PREFERRED PROJECT REPORT

**12-38 AND 40 BONAR STREET AND
5 LOFTUS STREET, ARNCLIFFE**

DECEMBER 2009

DRAWN BY		TITLE	March Shadows
DATE		DATE	9am - 12noon - 3pm
CHECKED BY		DRAWN BY	
SCALE	1:500	PROJECT NO.	
		SHEET NO.	8000
			A

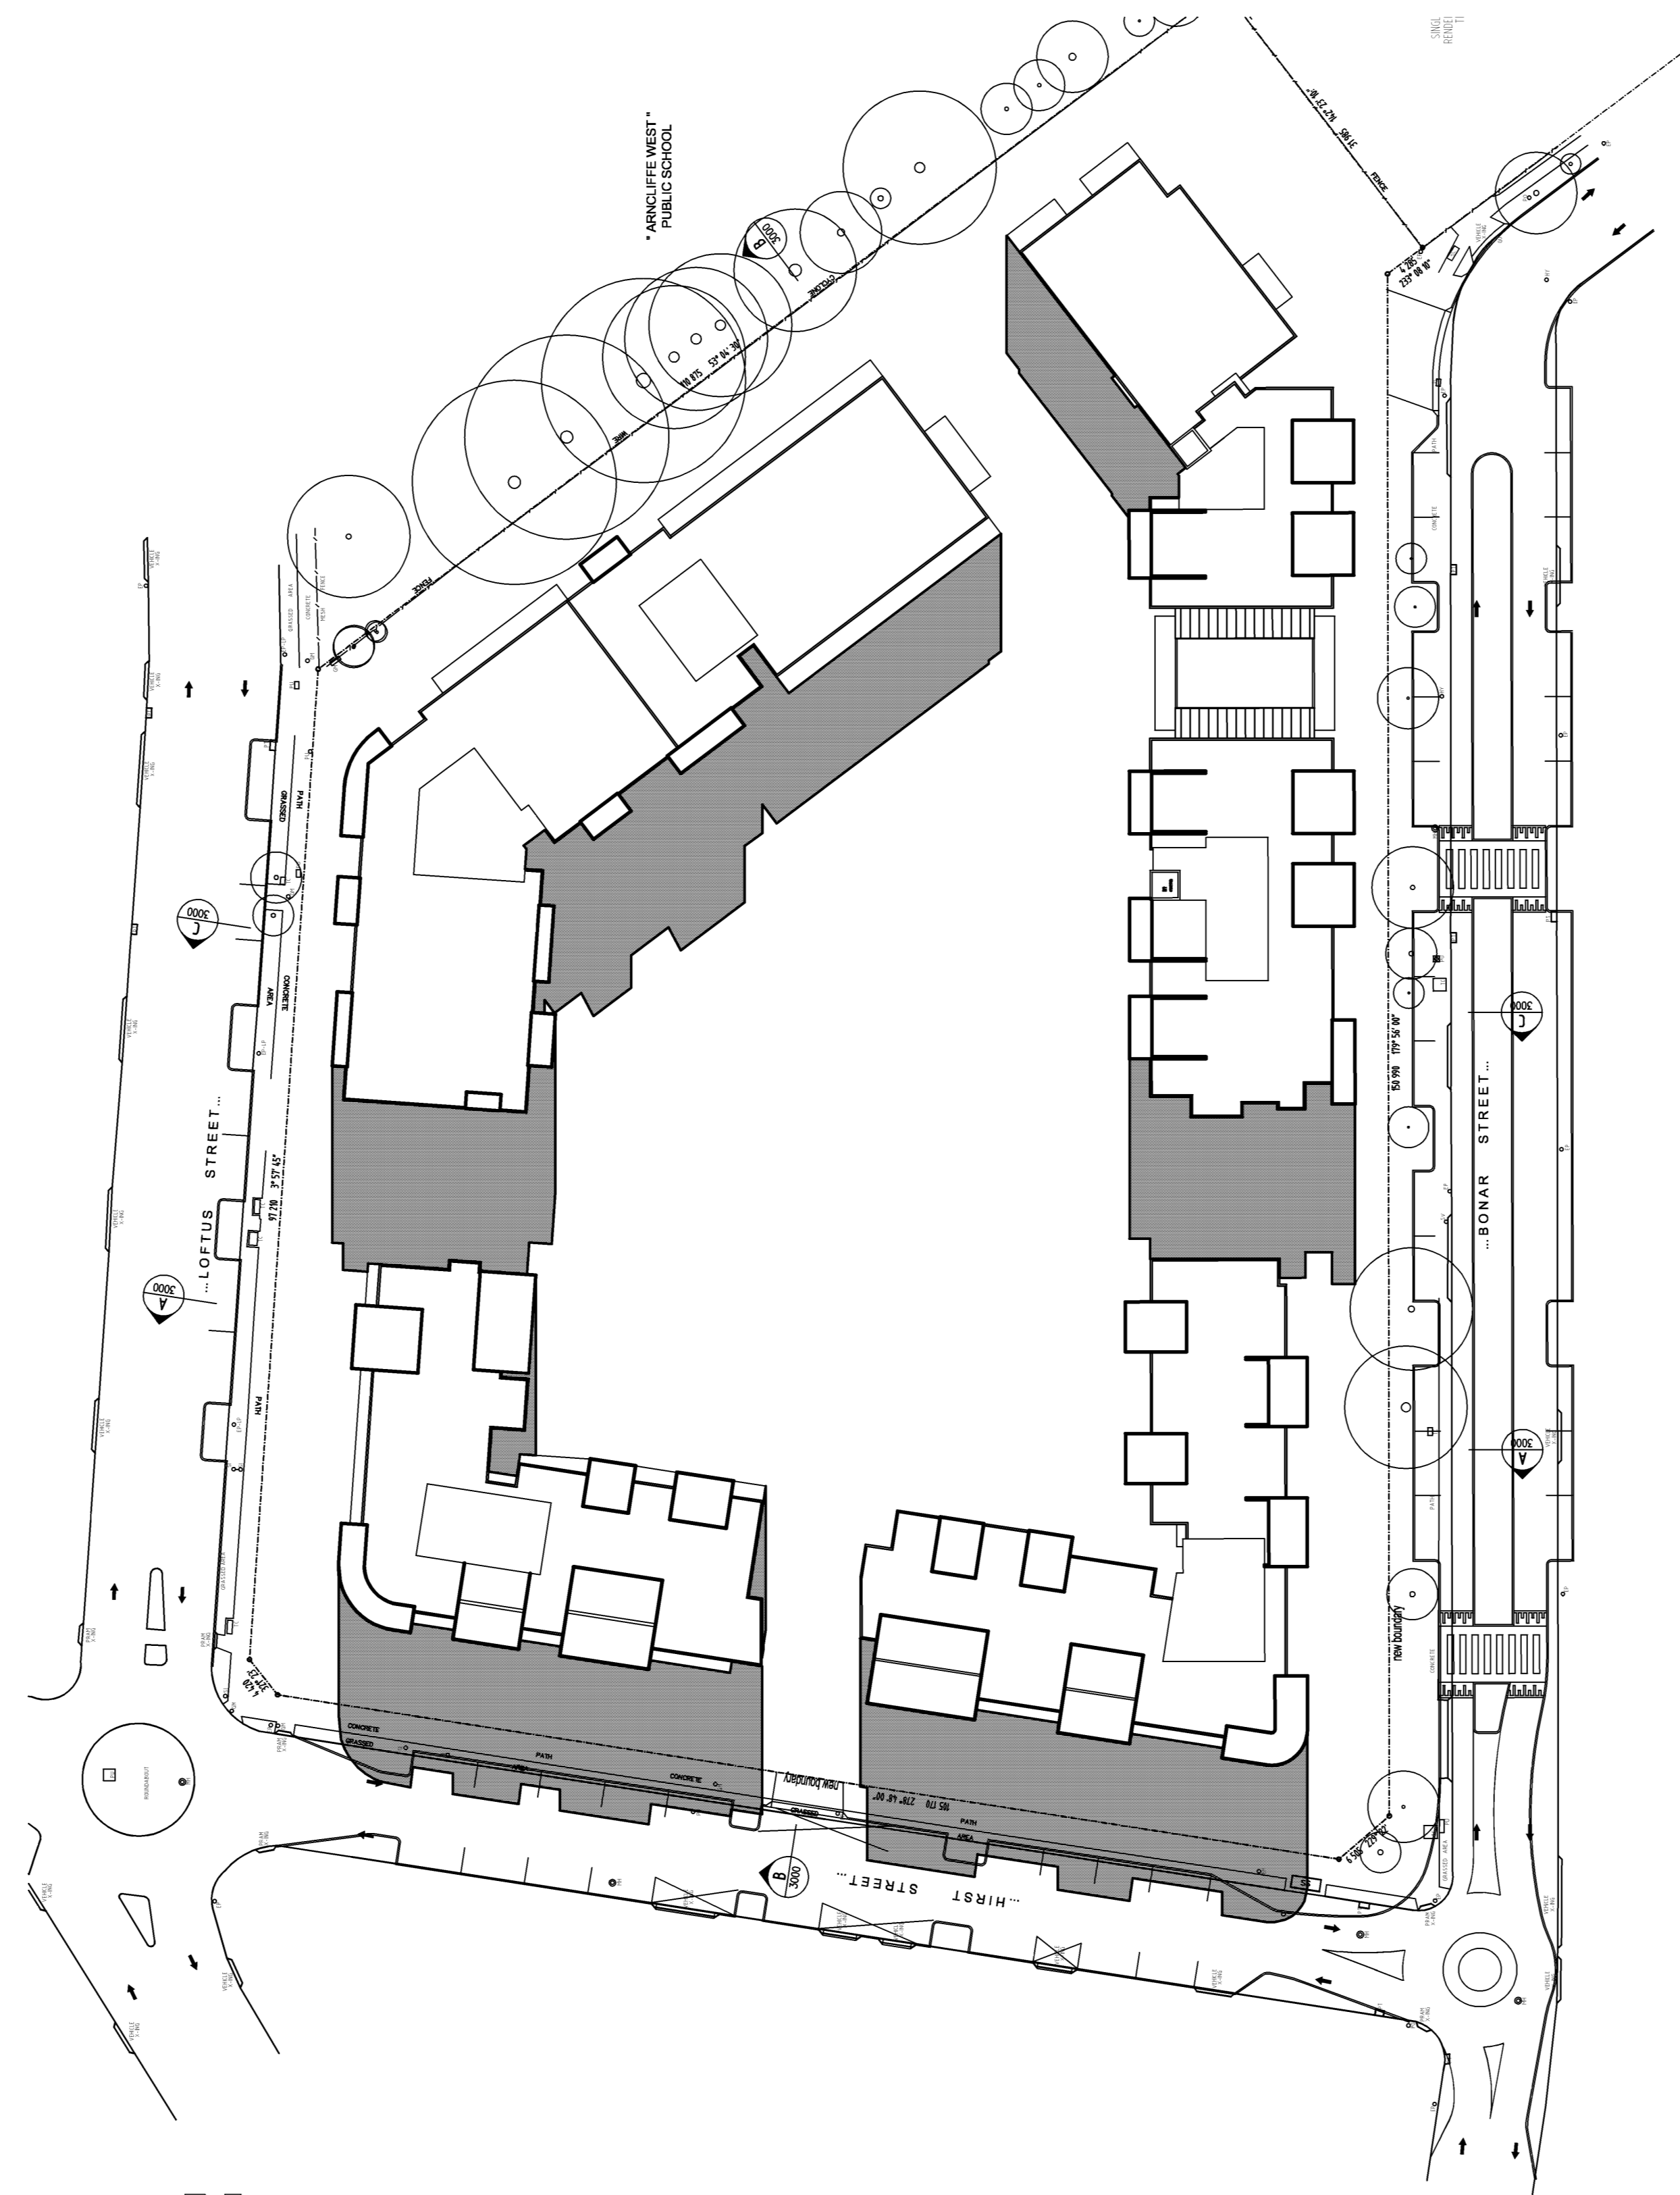
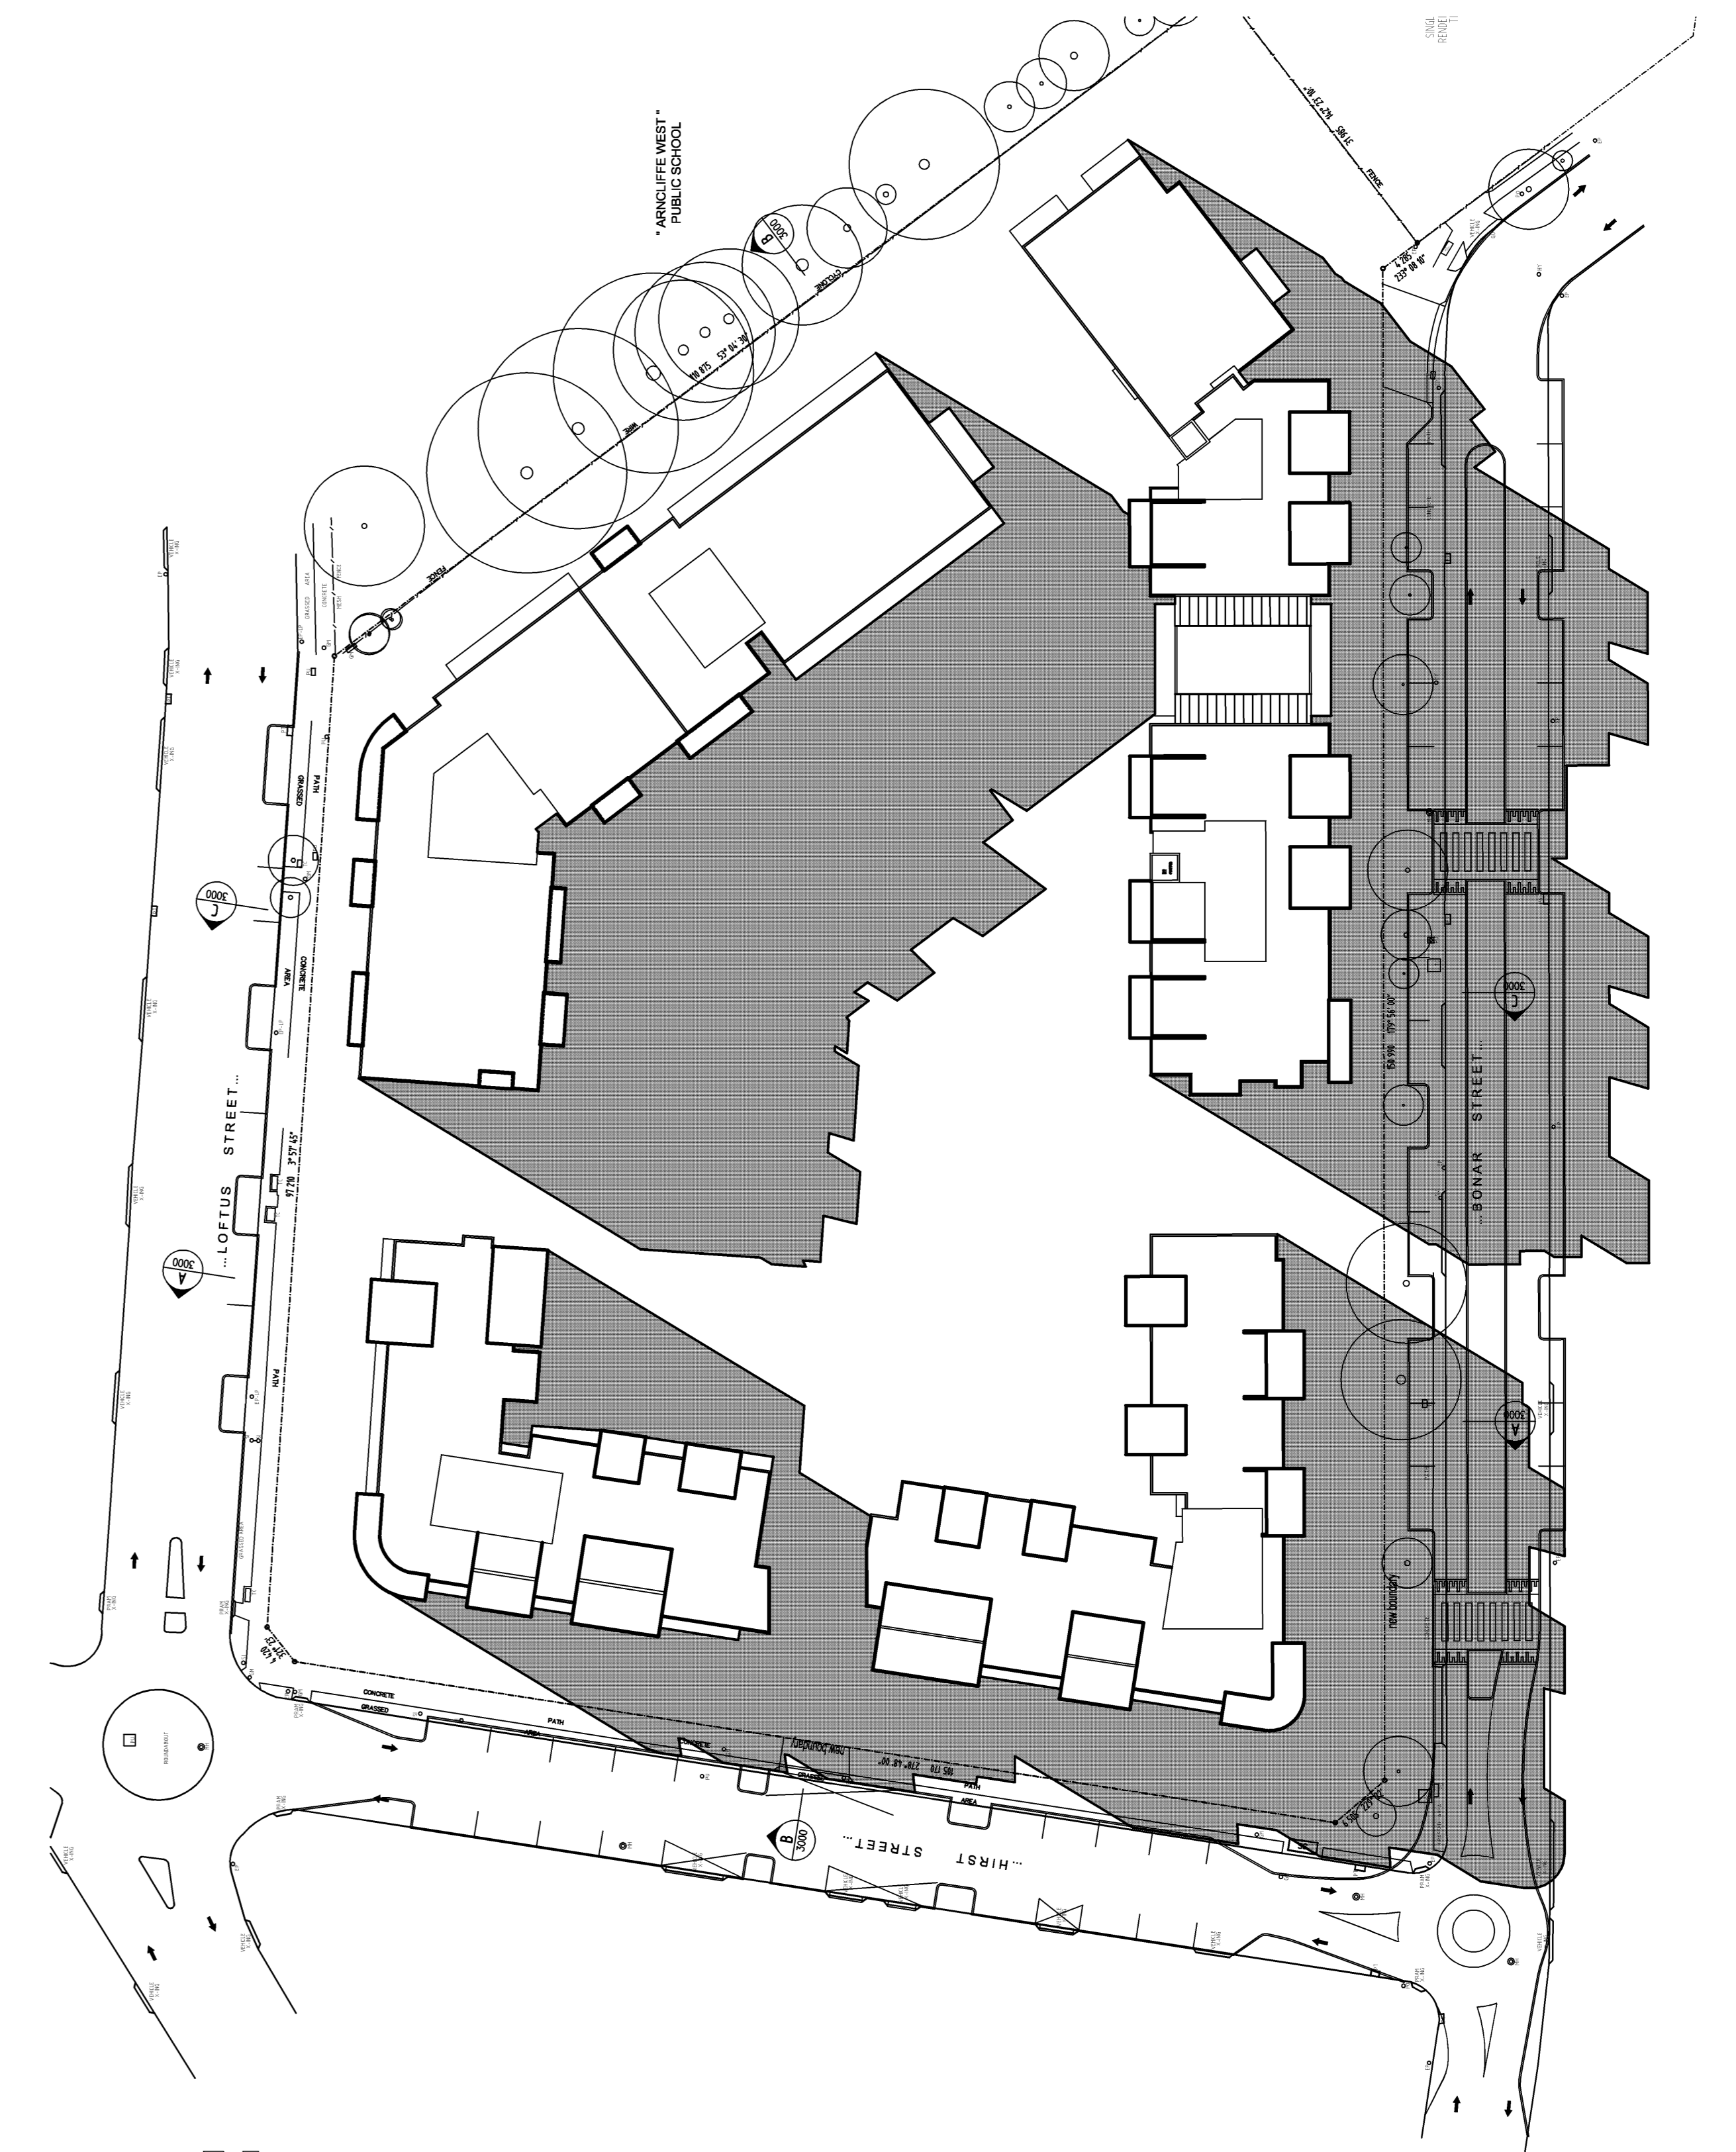
Clause 53A(2D) of the Rockdale Local Environmental Plan 2000 states that the maximum height may be exceeded by 3 metres *“but only if the consent authority is satisfied that any such variation from the maximum building height specified for the land in that diagram will not have a material adverse effect on the amenity of the occupants of nearby land.”*

Accompanying this report is additional overshadowing diagrams that show the extent and location of additional shadows cast by the additional height to Buildings A and D.

During December 21, the additional shadow cast is only evident at 9am and 3pm and affects only a small part of Loftus Street and Bonar Street, respectively, and a small part of the internal courtyard of the proposed development.

At June 21, the additional shadow cast is also evident either side of midday. The additional shadow at 9am will be cast towards the future Bonar Street Precinct development site on the western side of Loftus Street; and the additional shadow cast at 3pm will be cast over the future Bonar Street Precinct development site on the eastern side of Bonar Street. No existing residential properties will be affected by the additional overshadowing.

At Equinox (March and September 21), the additional shadow cast will essentially be the median of the summer and mid-winter shadowing impacts. No existing residential properties will be affected by the additional overshadowing.
